PSA-CA-16-00088-854 – Updated Site maps

From: Steph Mifflin
Sent: Tuesday, April 05, 2016 10:24 AM
To: 'sledhead.jnk@comcast.net'
Subject: Shoreline Exemption Permit
Attachments: PSA-1883270007-report.pdf, doc06515220160405103559.pdf

Detail A

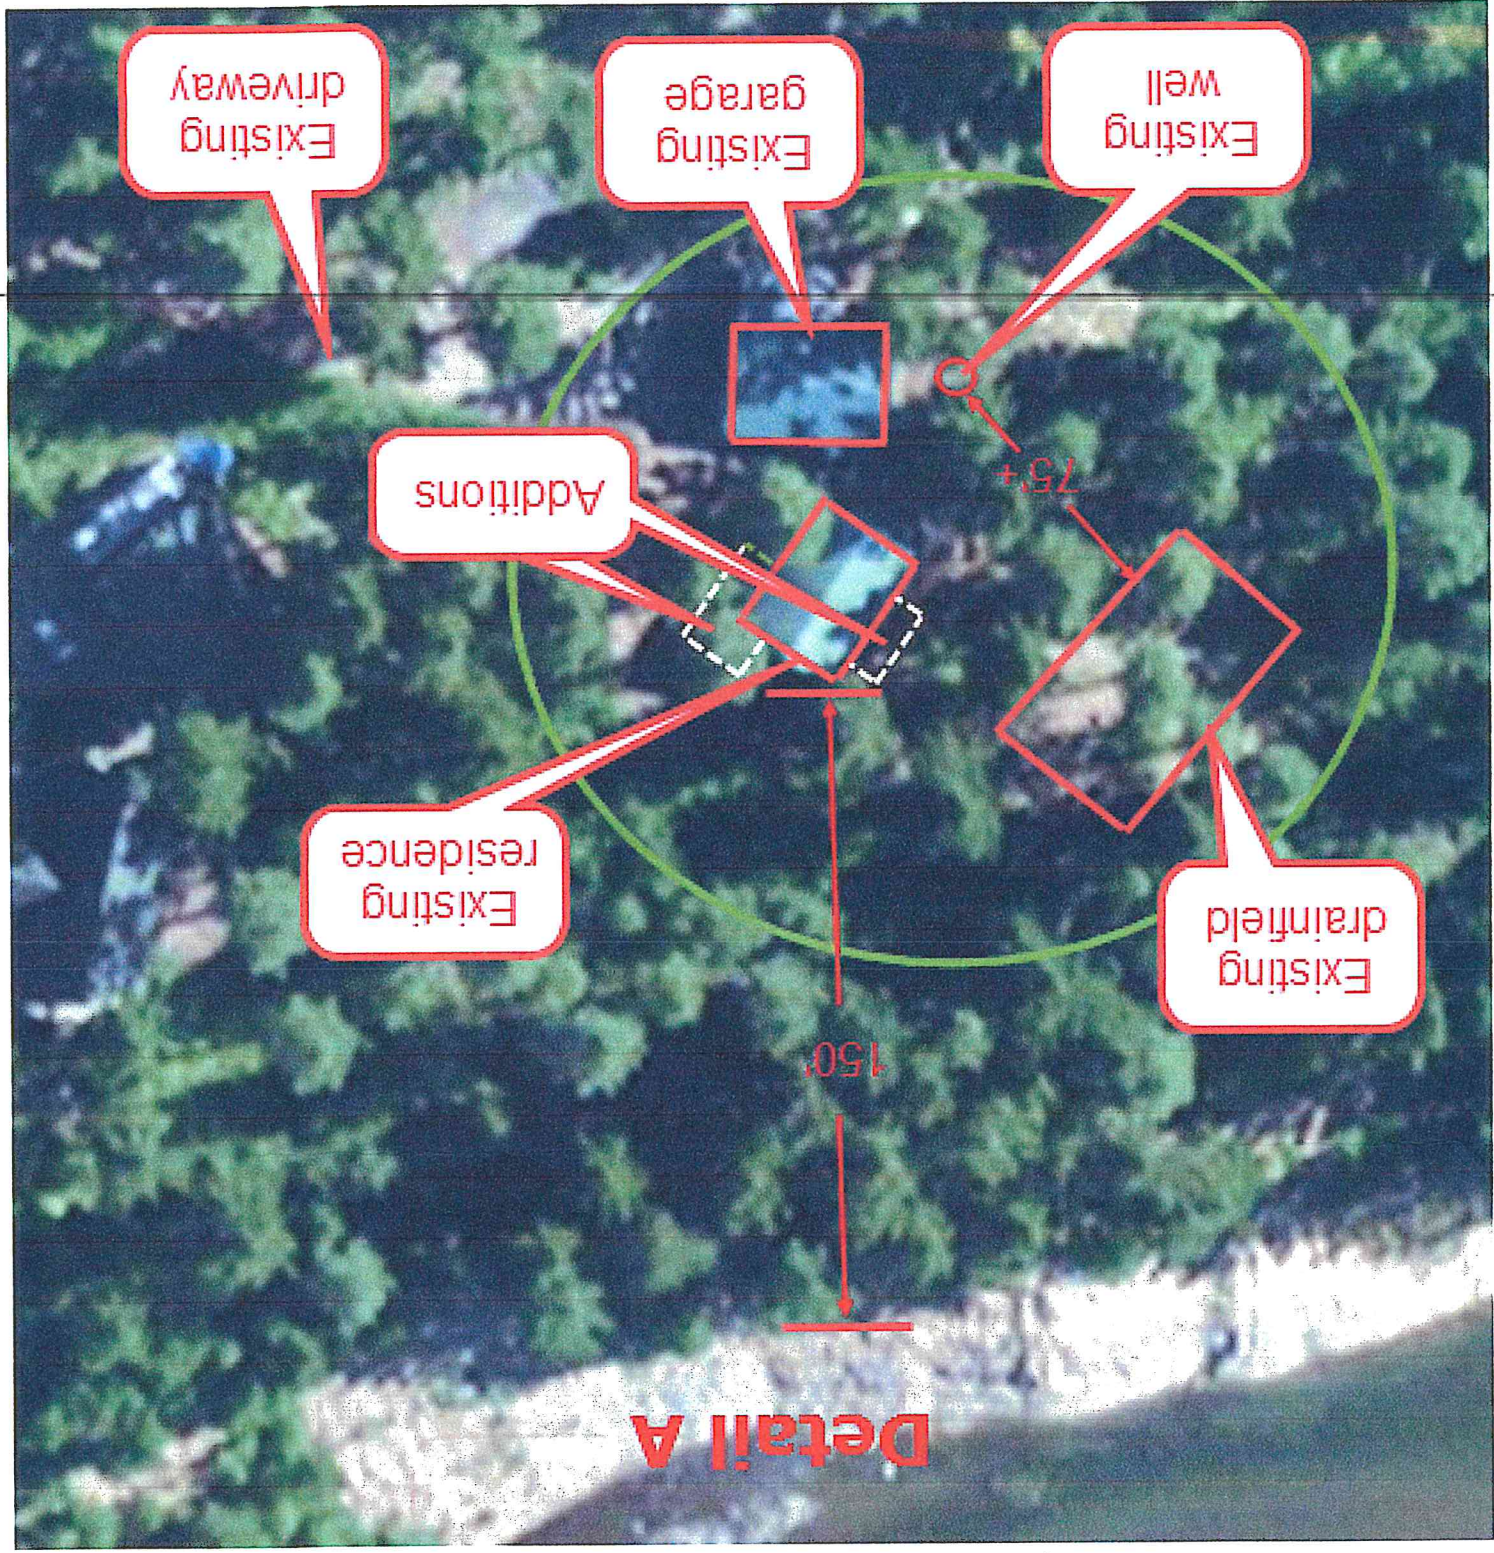
Per your PSA (see attached) we need the horizontal distance from the ordinary high water mark. The easiest way to do this is to make a drawing, to scale, similar to the one I've attached. Don't laugh at my awesome skills! ;) You can email it directly to me and I'll add it to the file.
